## ISH8 Pt2

Time is 11:30 and this issue specific hearings resume. So welcome back. Everybody catches step. Yes, I think you can hear as Mr Philpott, can't you? Yeah, just to make sure that so yes, I can. Excellent that that's good. Thank you. So I think we're now on to an item number 5 on the agenda, which is designed landscape and visual effects. I'll hand over to Miss Metcalfe on this one.

So we're now on to agenda item 5, Design landscape and visual effects. Question one is to the applicant within the design code document that was provided at deadline 4, which is Rep 4046. Paragraph two, point 1.2 includes a list of buildings that would be subject to the design code. However, this list doesn't include any

Figure 2.3

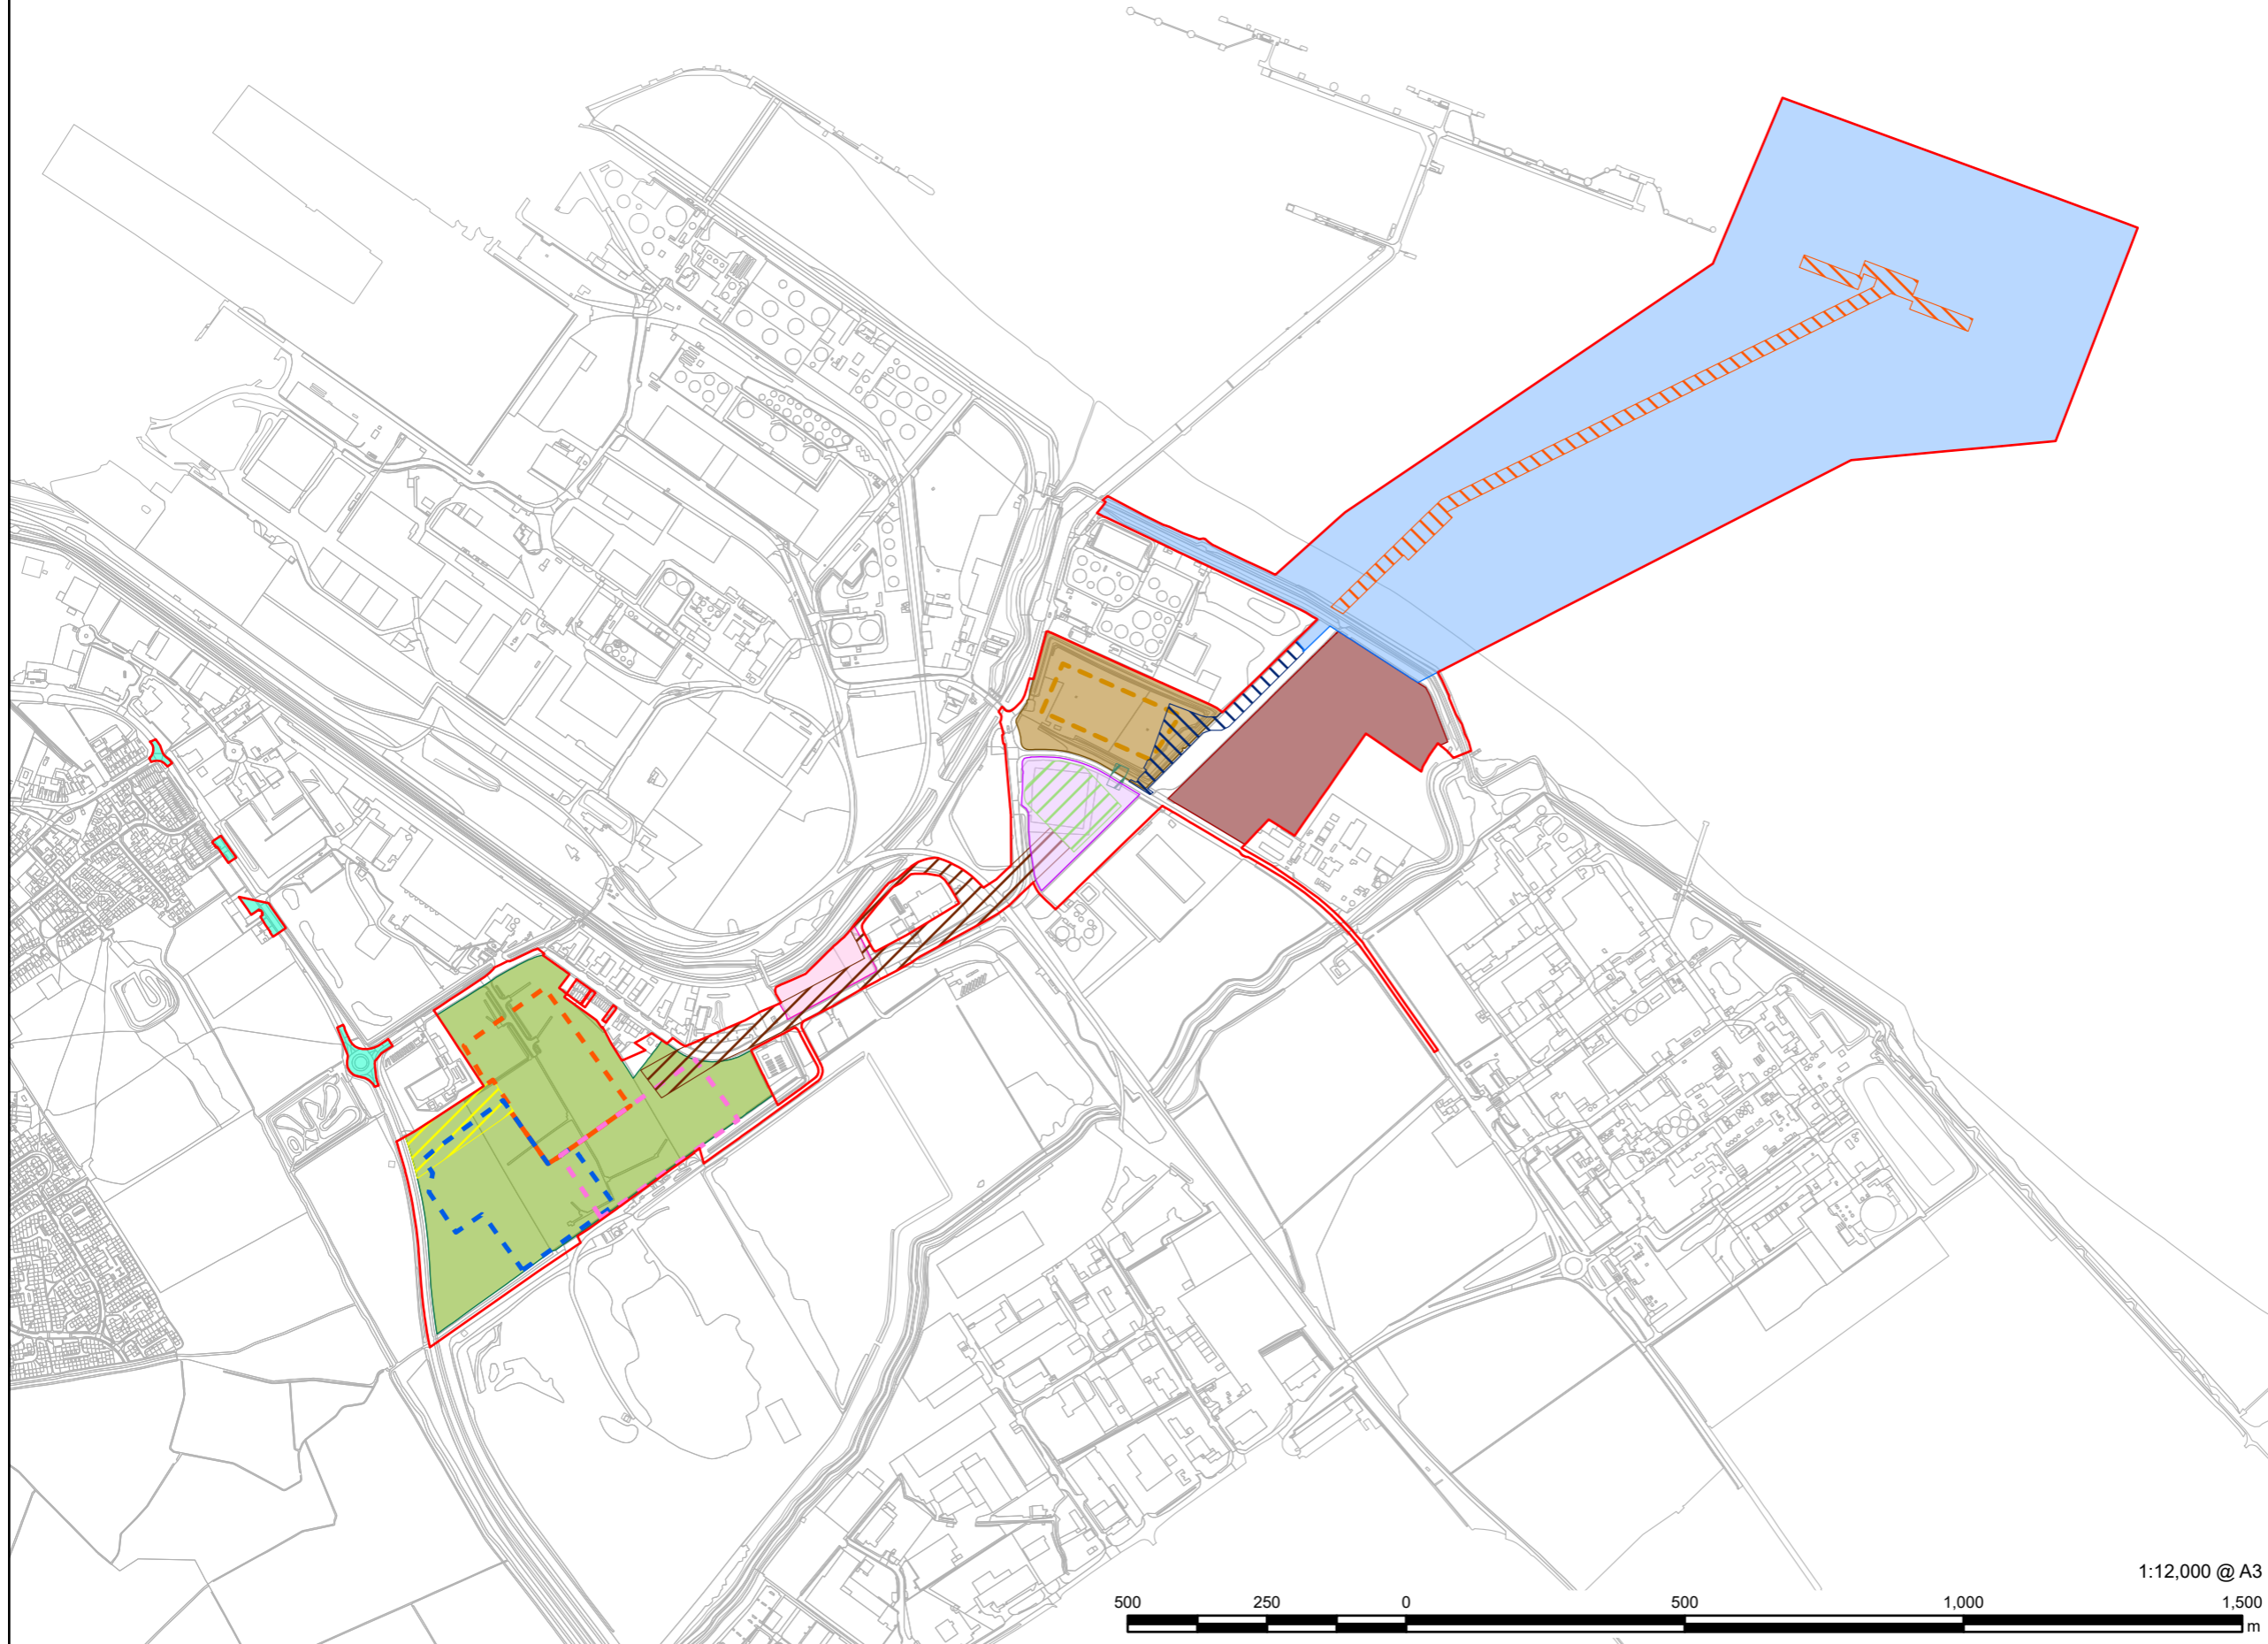
buildings that are in Work Area 3. Given that Work Area 3 includes a Welfare building and process instrumentation building, which building types included within that list for work areas seven? Could you explain why the buildings at work area three are not included? Thank you.

5:01  
operational buildings for operator use, albeit not normally manned. One of those buildings is the work and wealth at Work, the welfare and operations buildings located in Area 3.

5:21  
is it's generally a much smaller building. In this case that building is approximately 10 metres by 5 metres

5:35  
and it's set back considerably from the edge of the road, so behind the security fence,

5:44  
and it's also located closer to the operational structures, in this case the ammonia tank itself, which at 70 metres diameter and 40 metres high is a considerable structure.

6:00  
And so for those reasons, the Welfare and operations building located in works three was not considered to be a public facing building.
